Ribble Valley Borough Council

Address: The Tyremen 28-30 Parson Lane Clitheroe

Proposal: Approval of details reserved by conditions 3 (Materials), 4 (Rooflights), 5 (Boundary Treatments), 7 (Highways Works), 10 (Drainage), 11 (Levels) on planning permission 3/2023/0789.

168 - 03_A

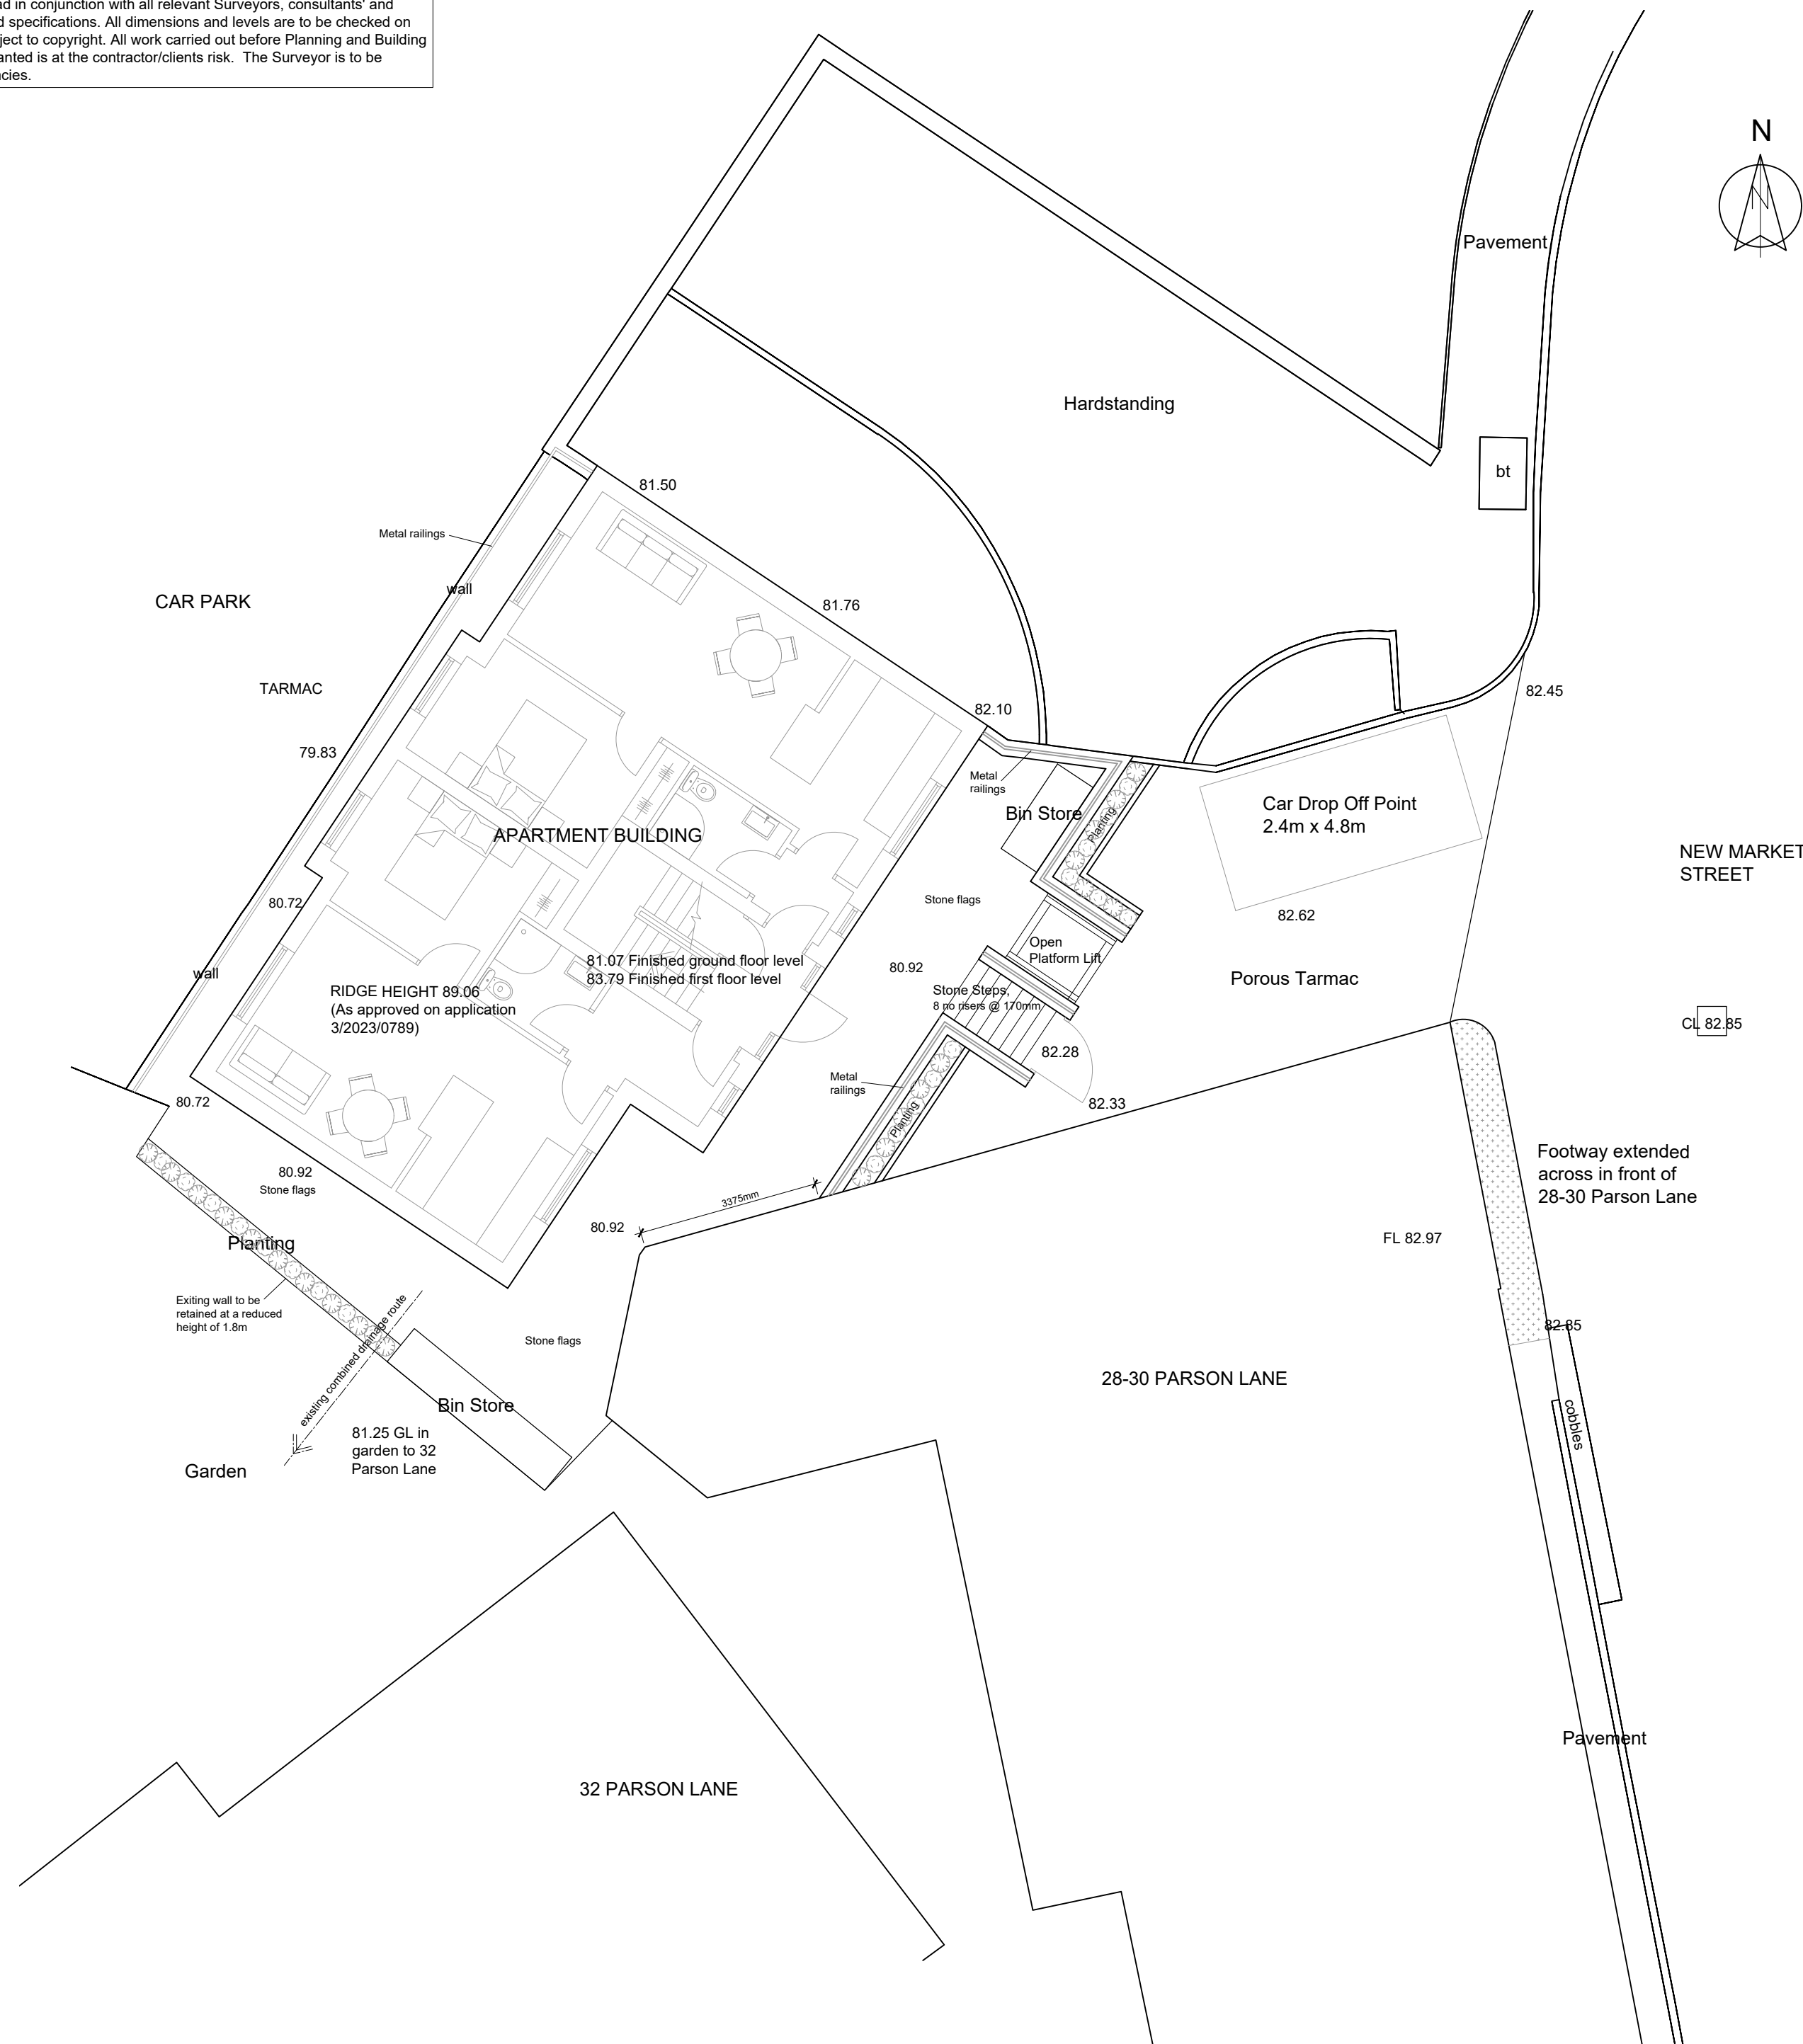
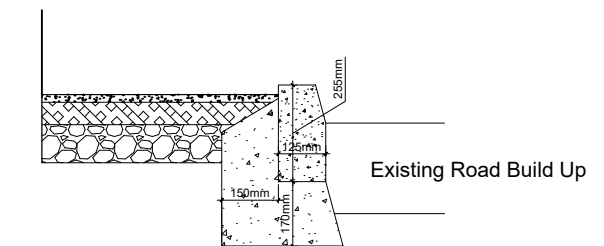
The drawing 168 - 03 has been assessed by Lancashire County Council under the S278 process and we have requested some minor technical changes.

We would recommend that the condition is not discharged until technical approval is given.
